**From:** Nigel Hunston  
**Sent:** 27 July 2016 15:57  
**To:** Louise Bearcroft  
**Subject:** 2016/92234 at location Unit 1 Kingsgate Centre, King Street, Huddersfield, HD1 2Q

KEY

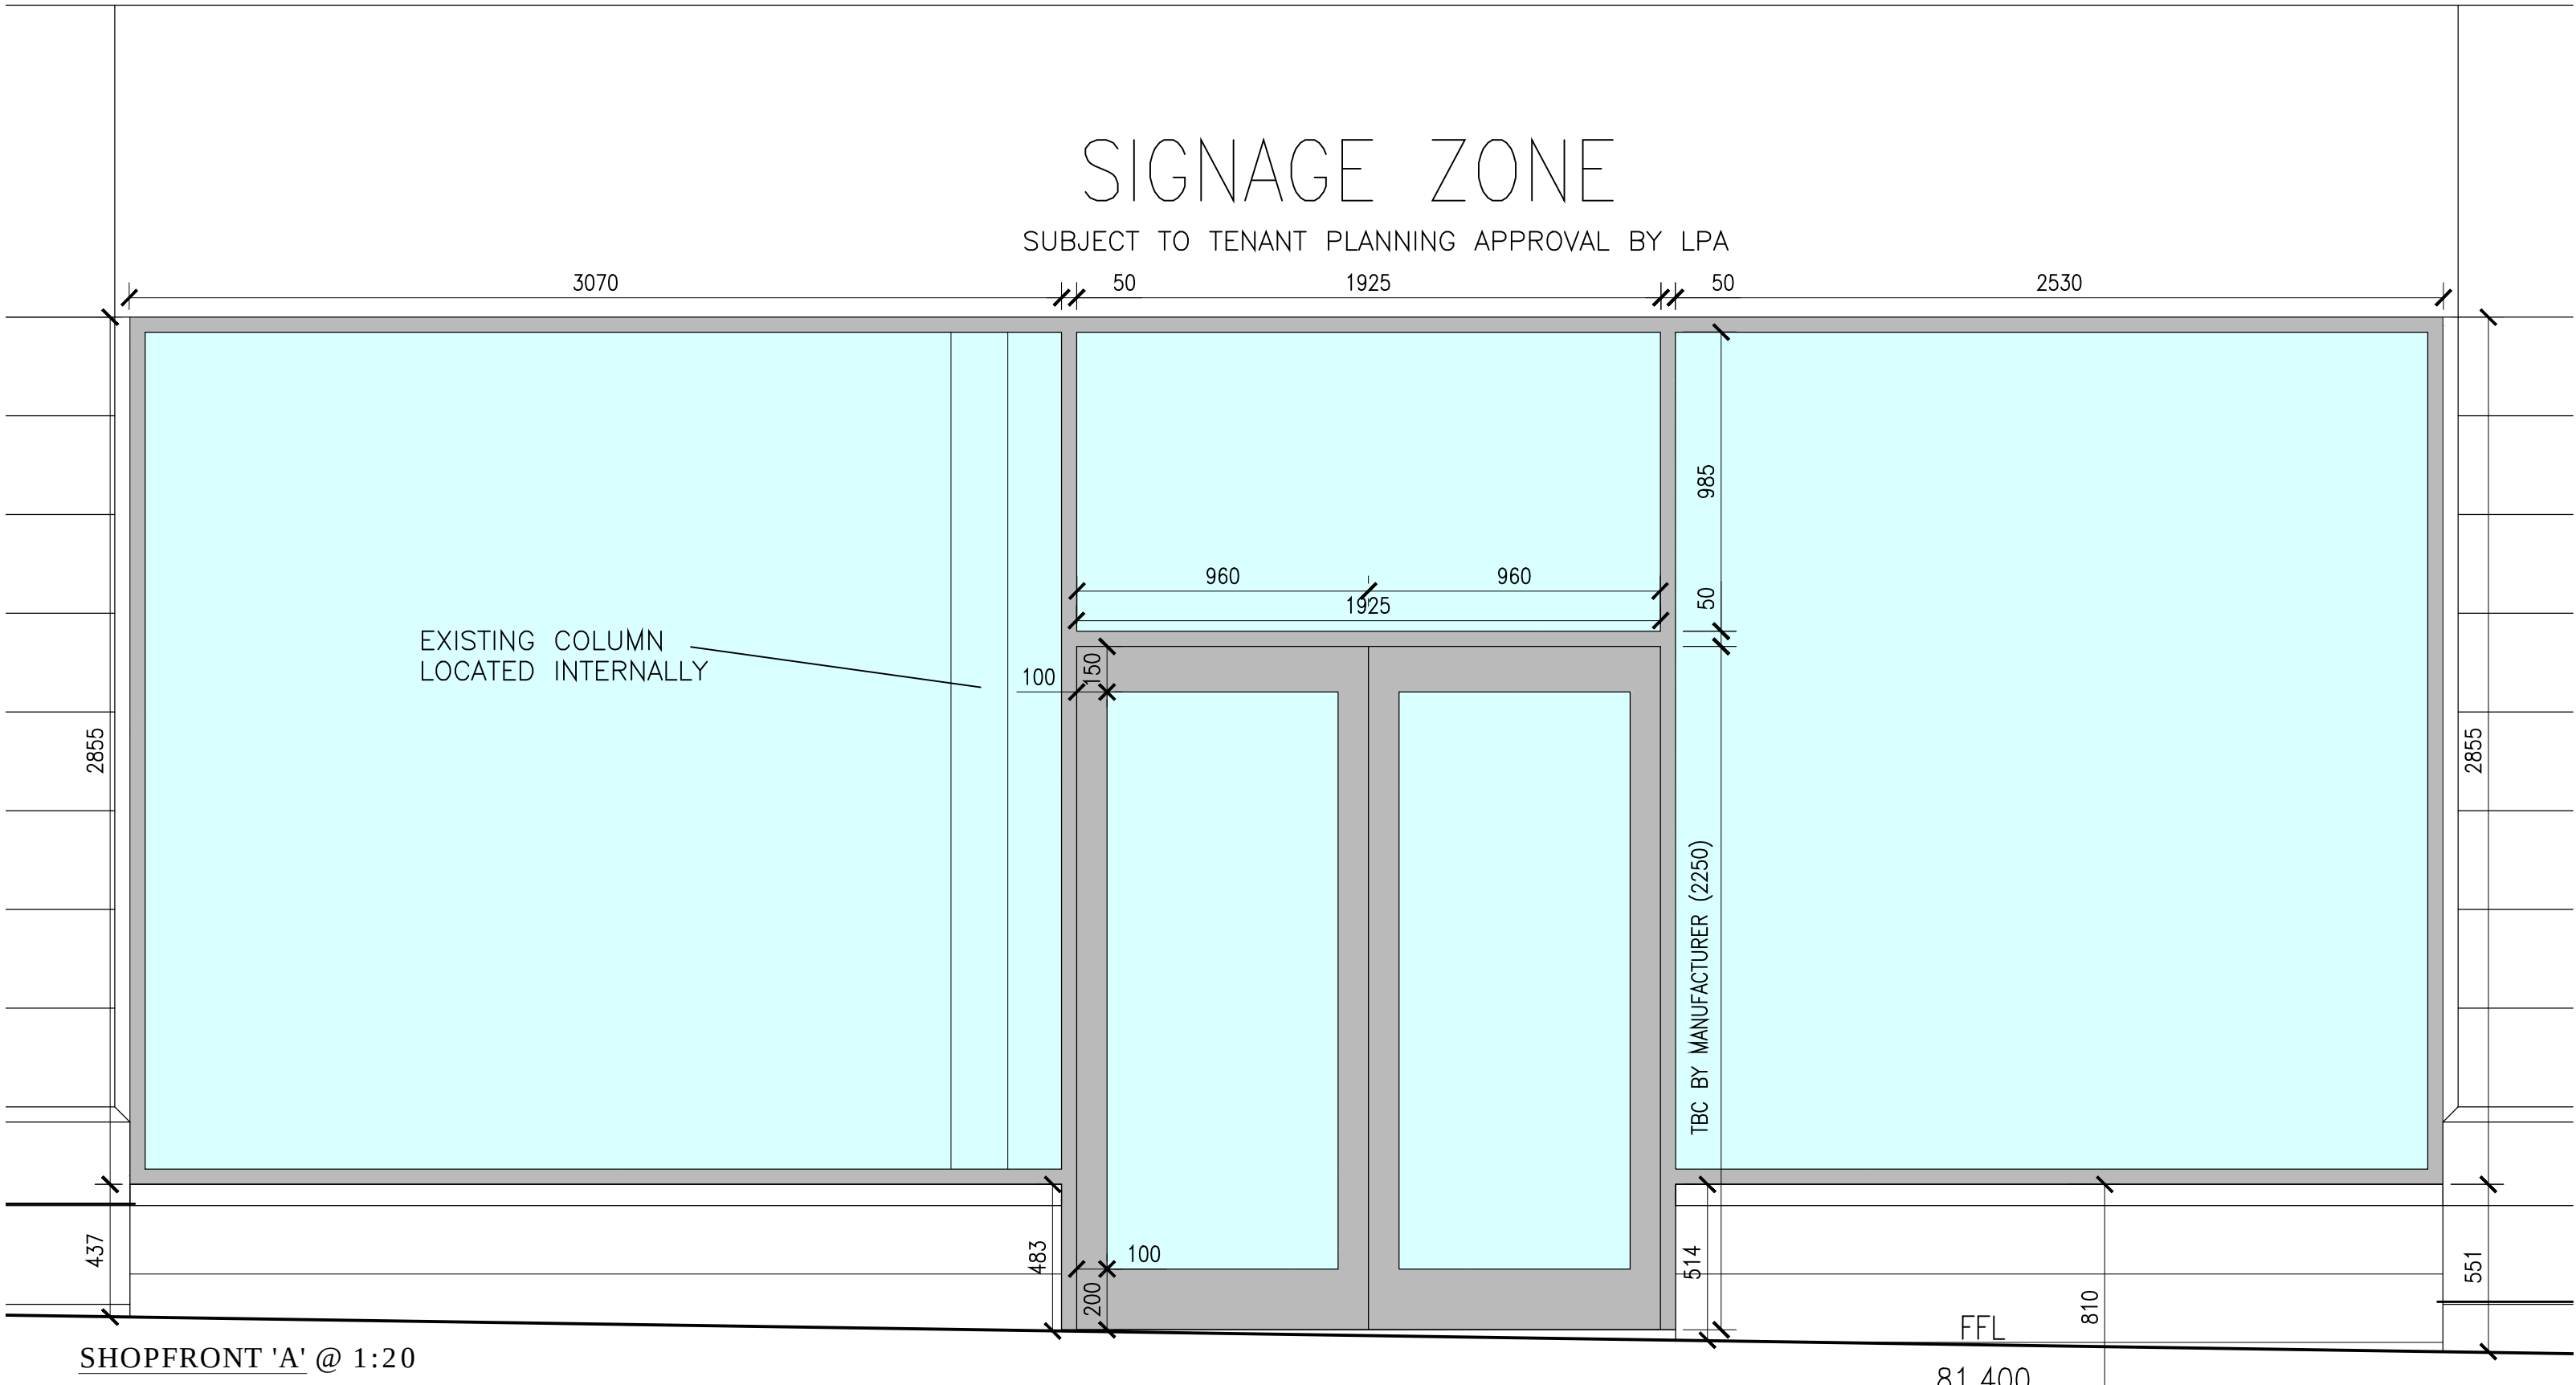
To assess the application fully, and whilst the elevations appear to show well-proportioned shop fronts, a drawing at 1:20 showing the detailing of the frame should be submitted.
